**KIRKLEES METROPOLITAN COUNCIL  
INVESTMENT & REGENERATION SERVICE**

Reference No:	<b>2023/44/91066/W</b>
Site Address:	Huddersfield New College, New Hey Road, Salendine Nook, Huddersfield, HD3 4GL
Description:	Discharge condition 6 (windows), 7 (bat and bird nesting) on previous permission 2022/90265 for erection of 2 storey classroom block
Recommending Officer:	Ellie Worth

**Application:** 2023/91066

**Proposal:** Discharge condition 6 (windows), 7 (bat and bird nesting) on previous permission 2022/90265 for erection of 2 storey classroom block

Biodiversity Enhancement Measures Plan

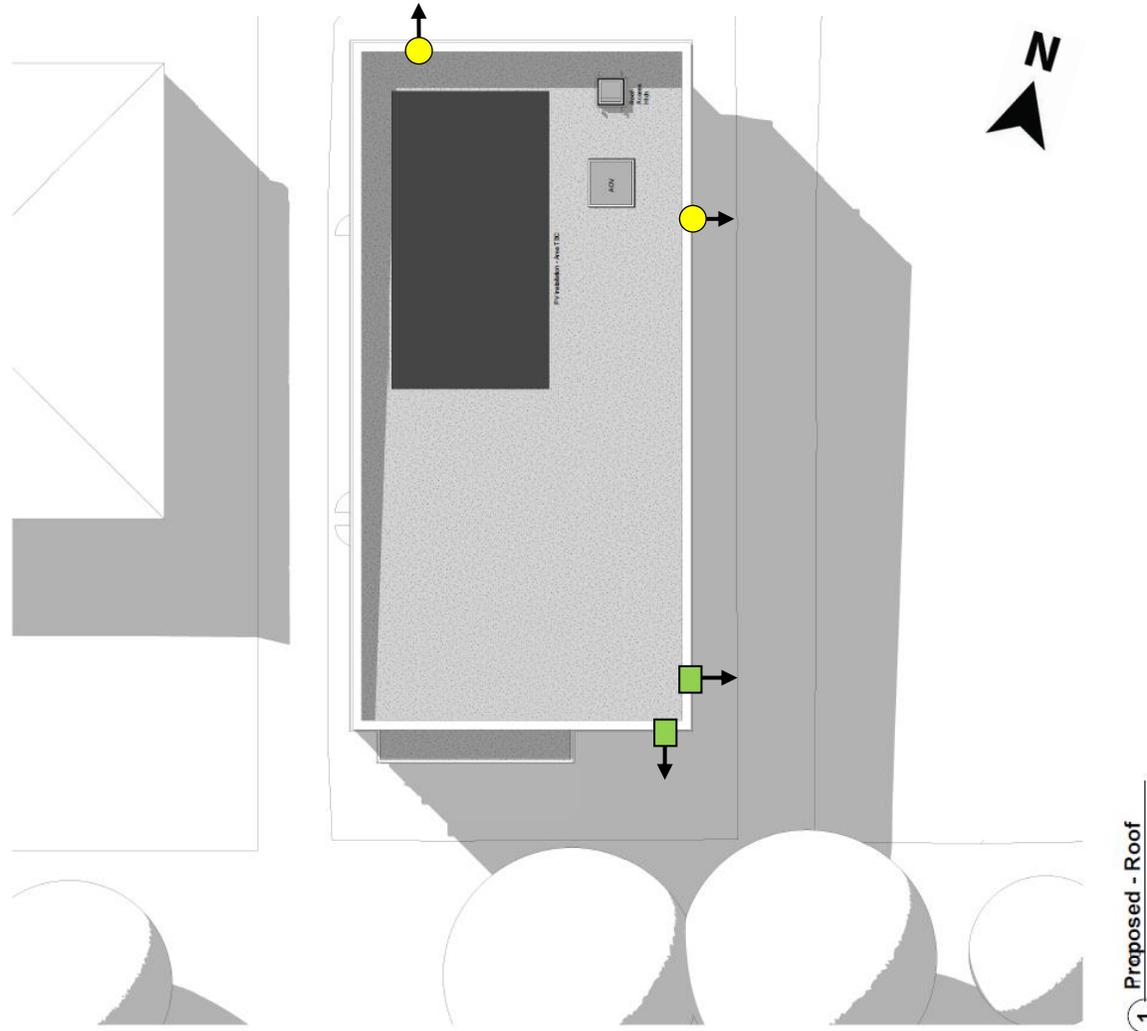
The document proposes bat and bird boxes to the north, south and eastern elevations of the new two storey classroom block. Such measures have been considered acceptable to ensure that provisions for protected species are integrated into the design.

Therefore, the information submitted can be supported, subject to the classroom being built in accordance with the biodiversity measures and retained thereafter.
